Please ask for: Ms Iqraa Malik
Email: iqraa.malik@terraquest.co.uk
Telephone: 0121 234 1390
Our Ref: FP/5/22/HH
Your Ref:
Date: 19th January 2022

Application for Planning Permission for Works or Extension to a Dwelling

Development: Erection of part single, part two storey front, side and rear extensions, pool plant room and pool, installation of vehicular crossover and driveway, following the demolition of existing extensions, garage and timber shed.
Location: 128 Limmer Lane Felpham PO22 7LR

DRAWING TITLE
PROPOSED SITE LAYOUT PLAN

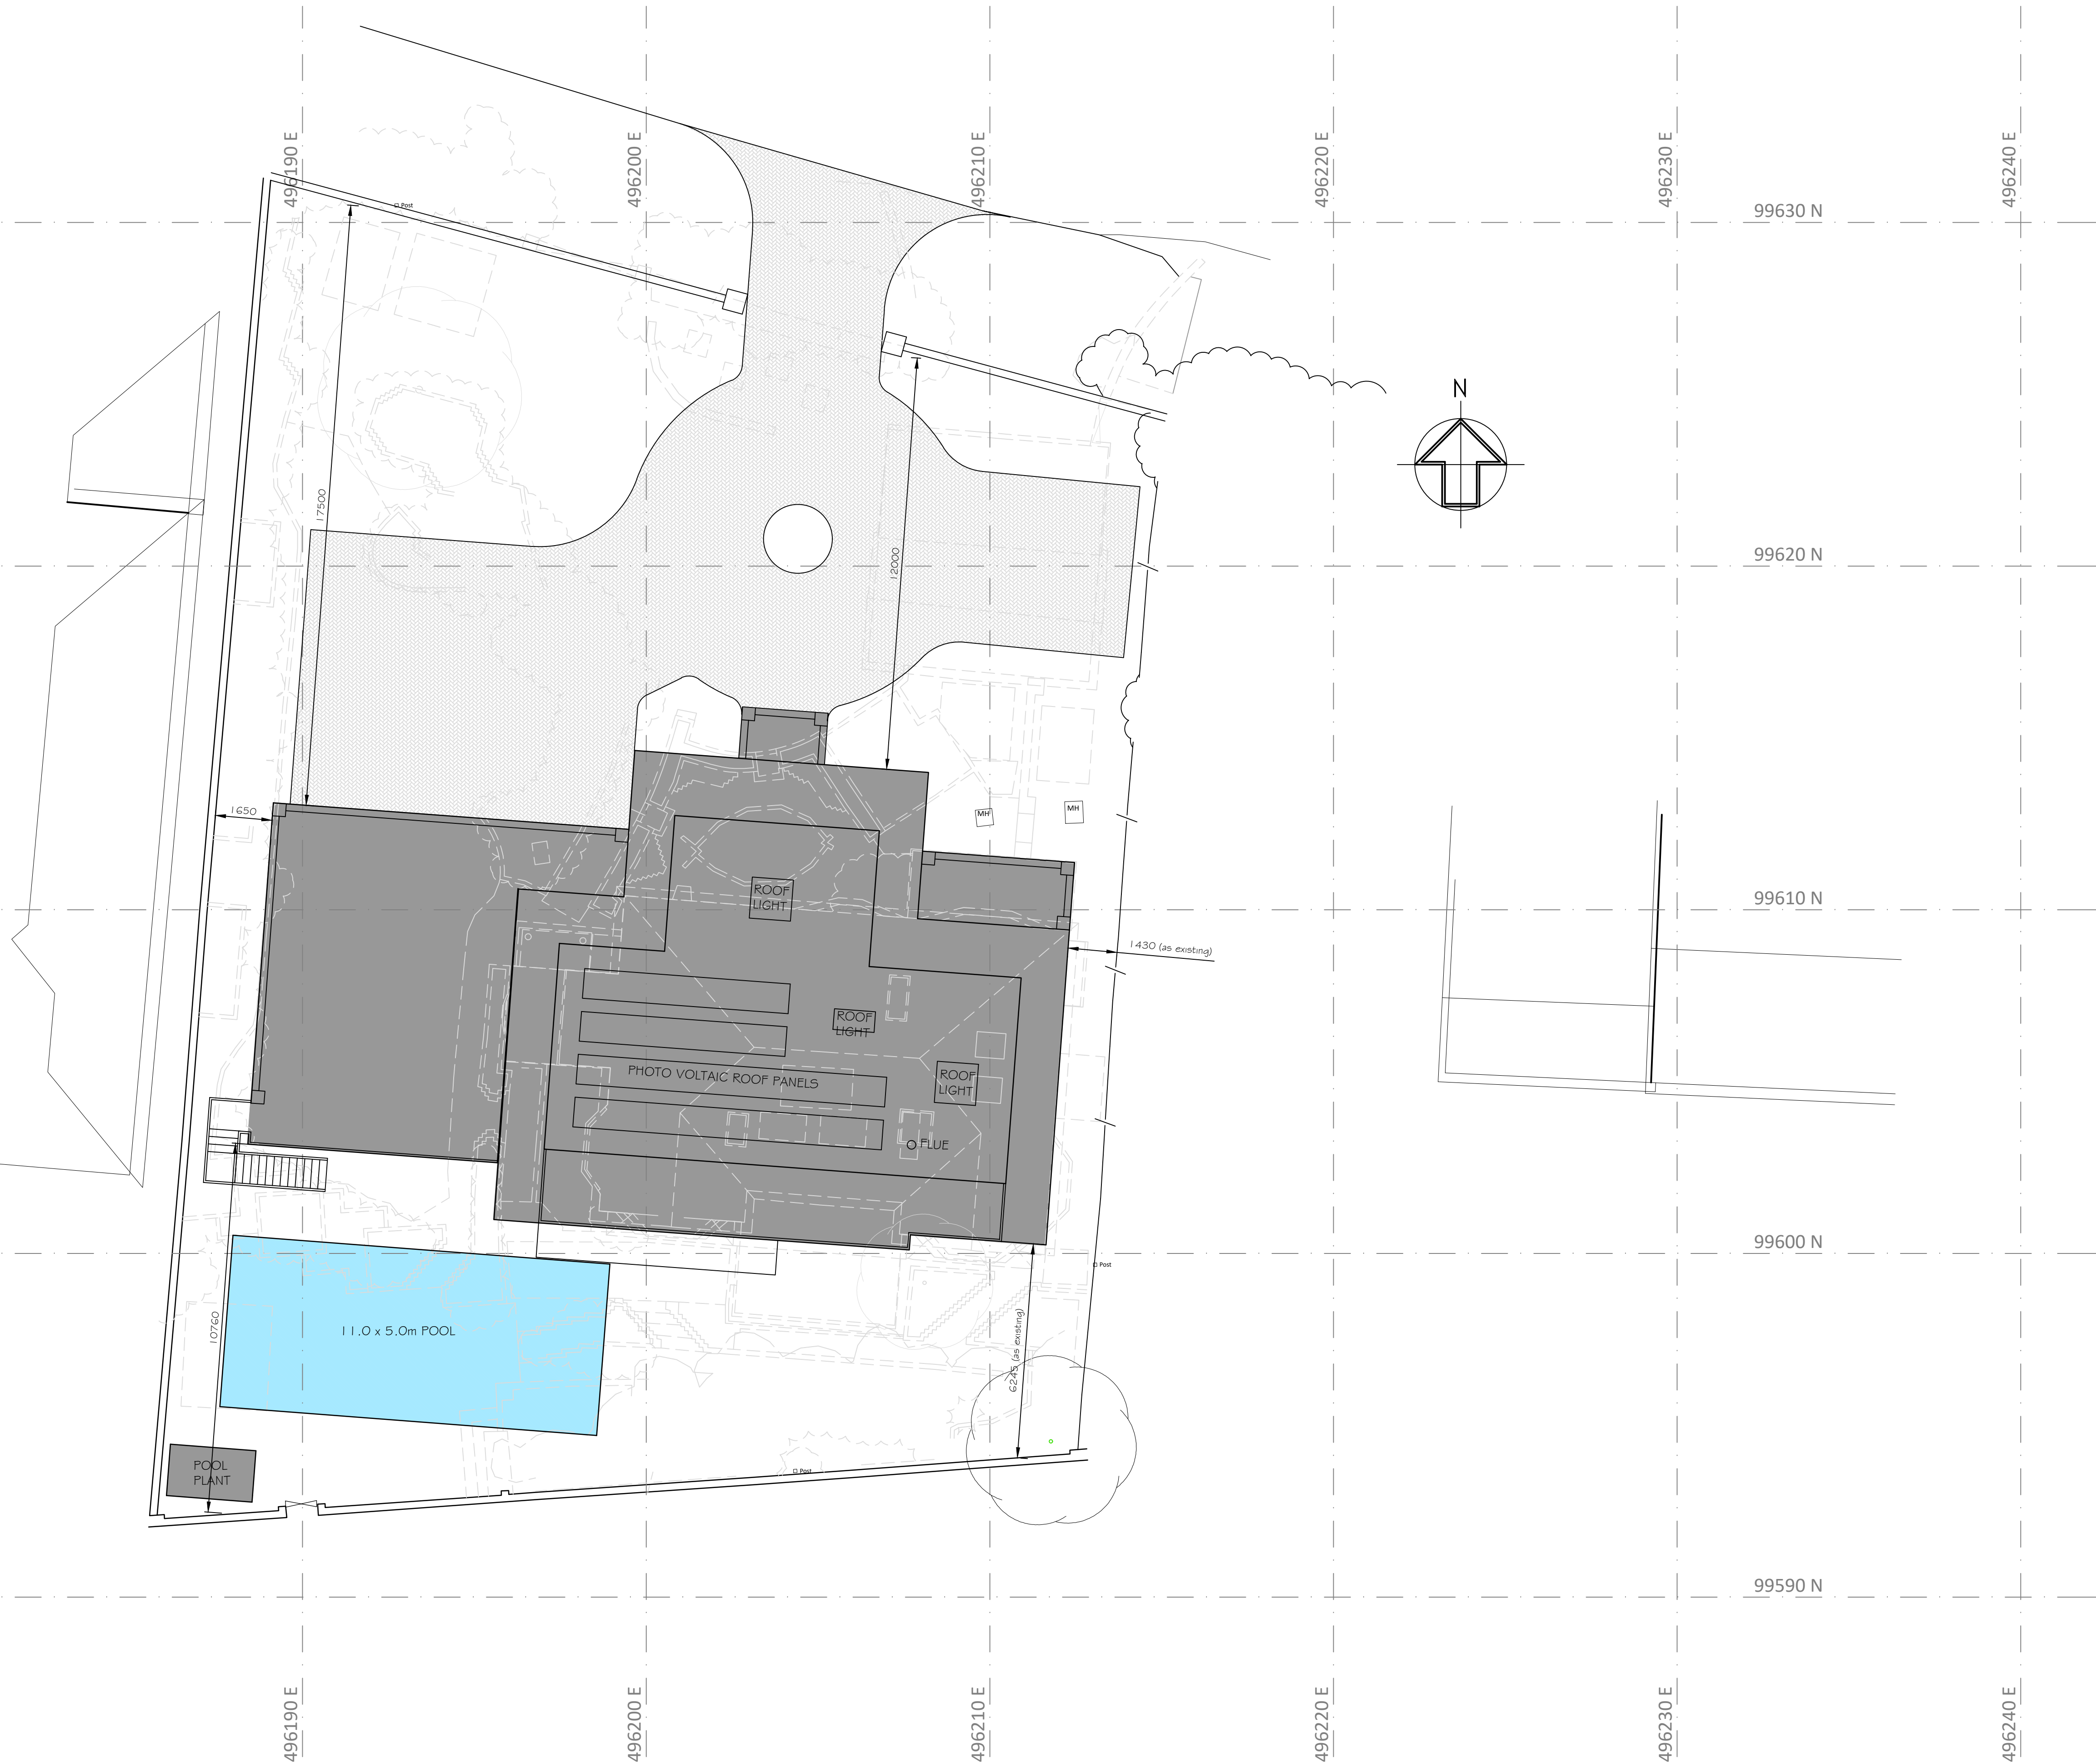
West Sussex County Council require that a visibility splay is provided. A splay is formed for a 30 mph speed limit road by measuring from a point 2.4m back from the kerb edge in the centre of the proposed access. A line should then be drawn from either side of this point for 43 m in each direction to the nearside edge of the carriage way. The splays must intersect land only within the control of the applicant, or within the publicly maintained highway.

The distance will increase with the speed limit of the road. If the road is 40 mph speed limit then the distance should be 120 m either side. For speeds above this please contact West Sussex County Council Highways for advice on what would be acceptable.

You are required to submit a scaled plan of the crossover showing the width and depth of the proposed crossover.
